ENG-SP19003-R3-PDR-redlines.pdf Markup Summary

Cursory comments. See comment letter also.

811 Know what's below.
Call before you dig.
CALL 3-BUSINESS DAYS IN ADVANCE
BEFORE YOU DIG, GRADE, OR
EXCAVATE FOR THE MARKING OF
UNDERGROUND MEMBER UTILITIES.

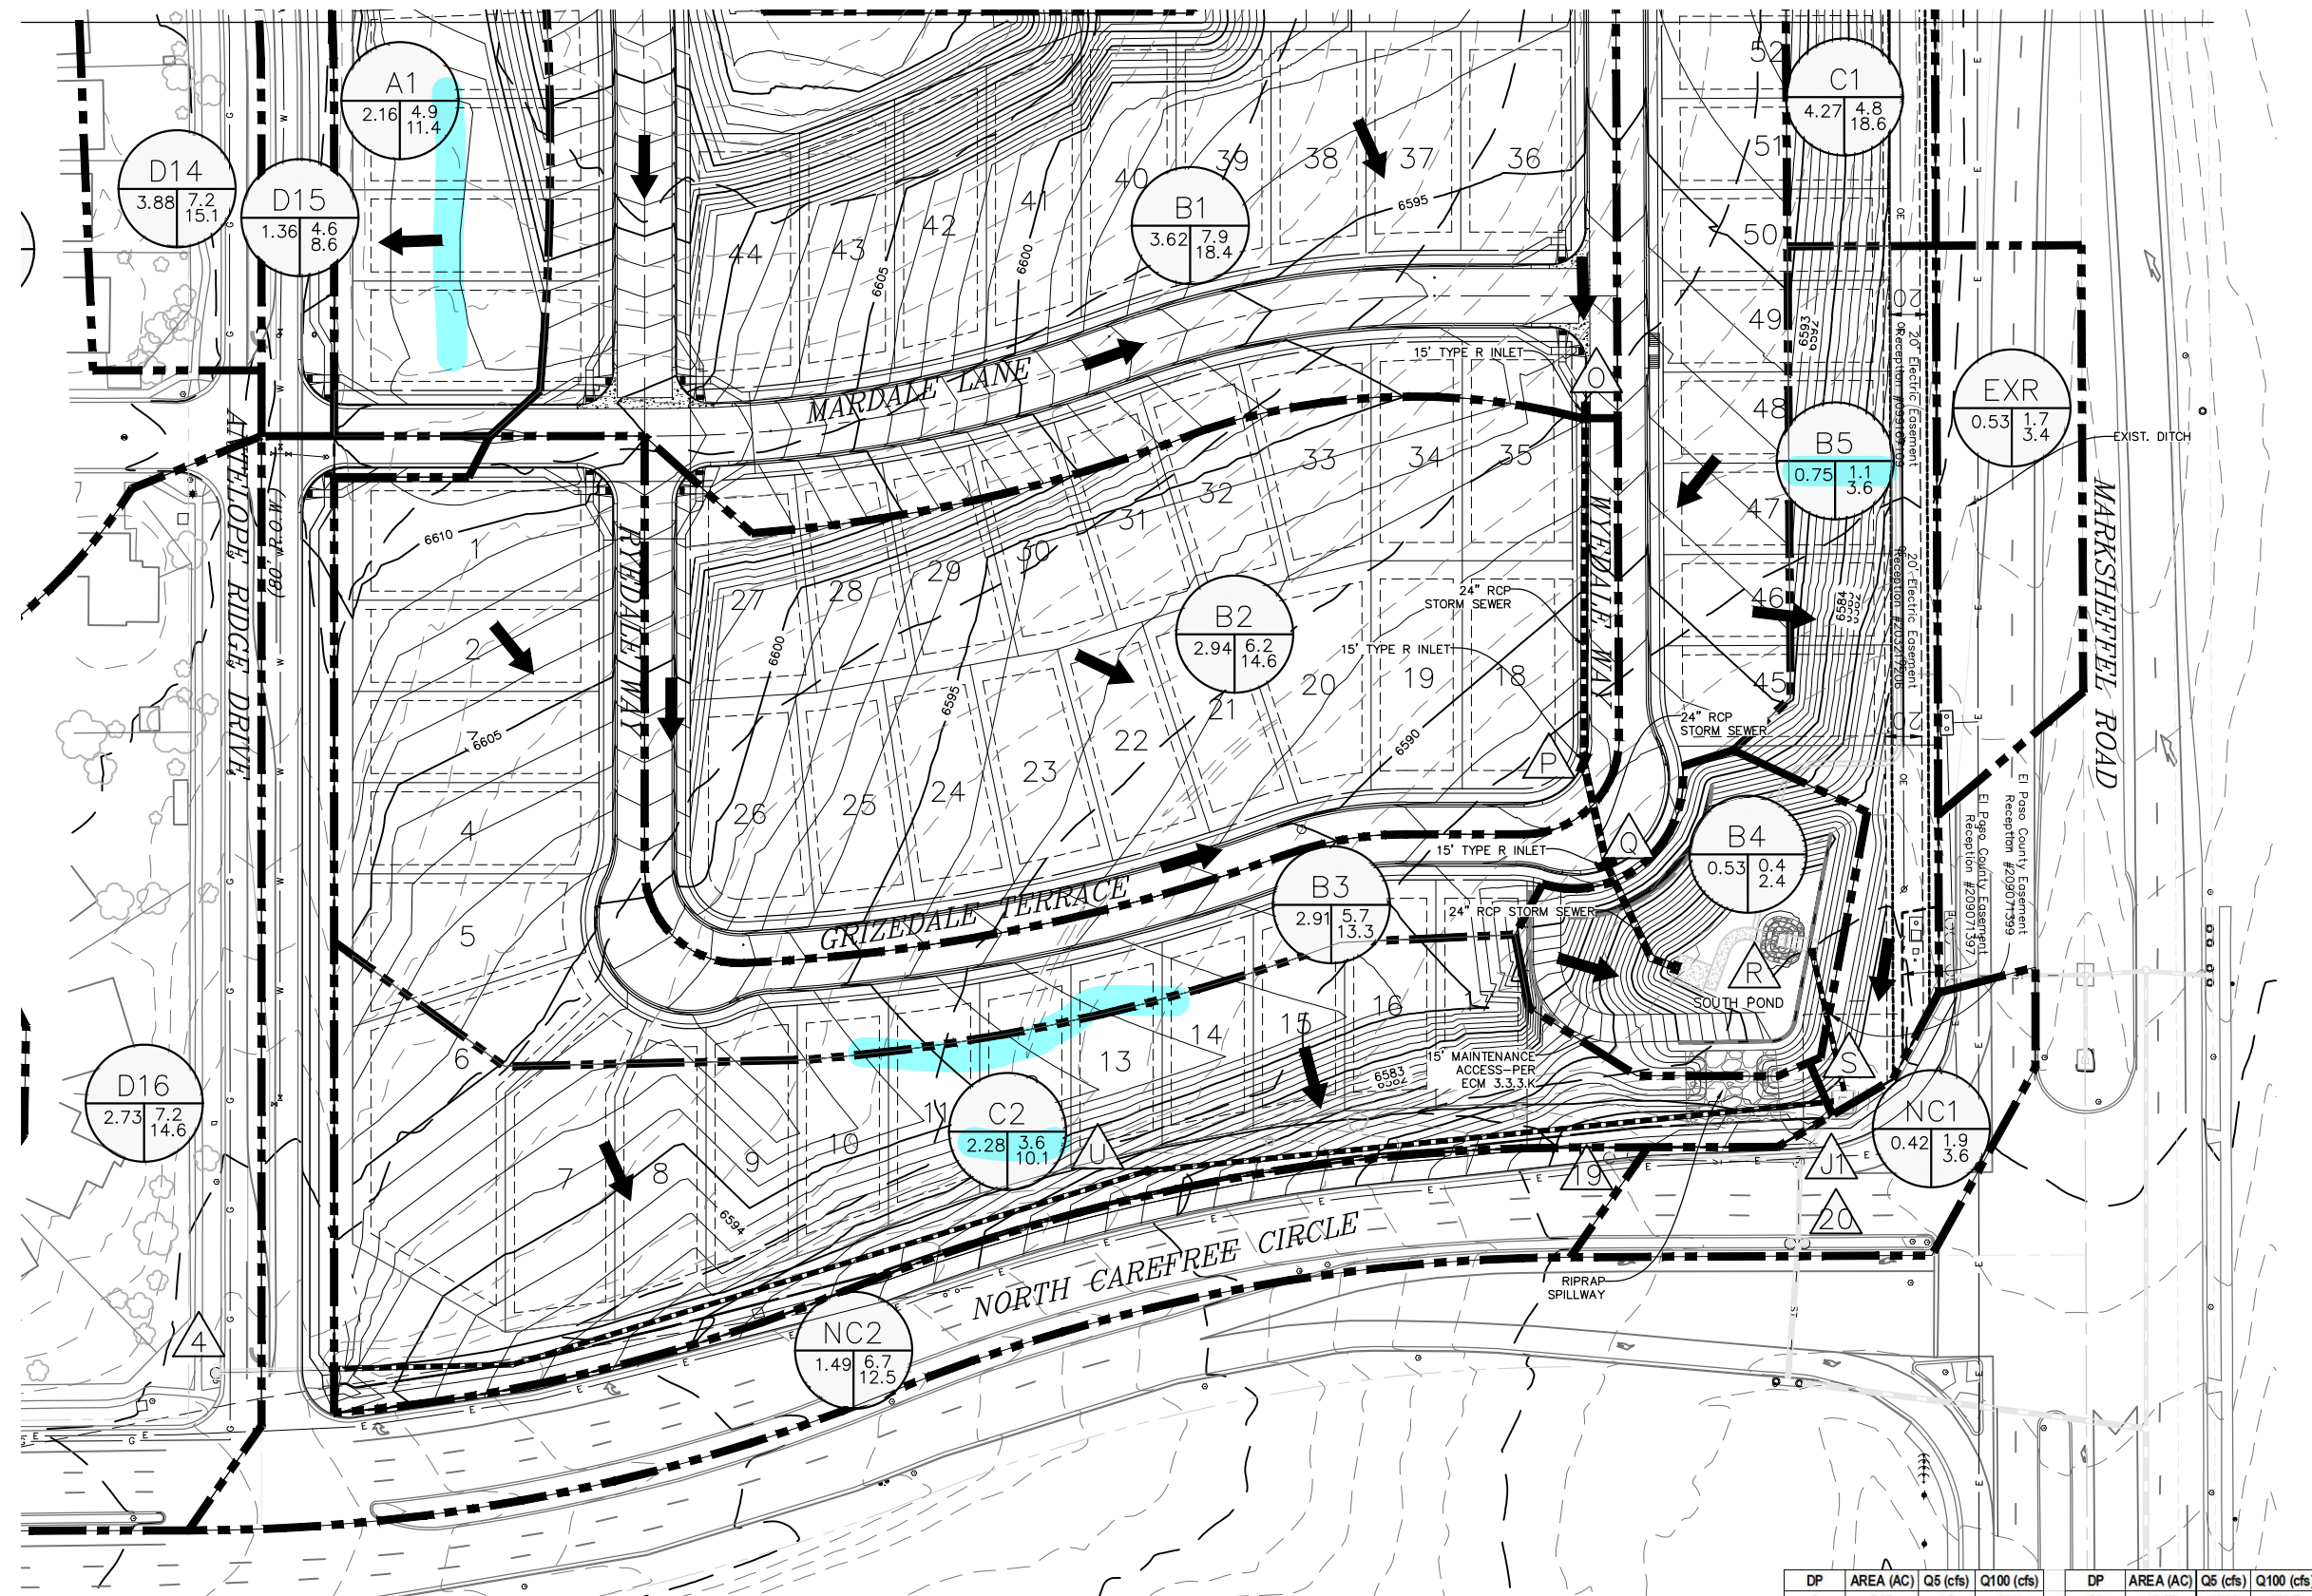
Provide stabilized rundown

Offsite swale with easement?

See Prelim. Plan redlines.
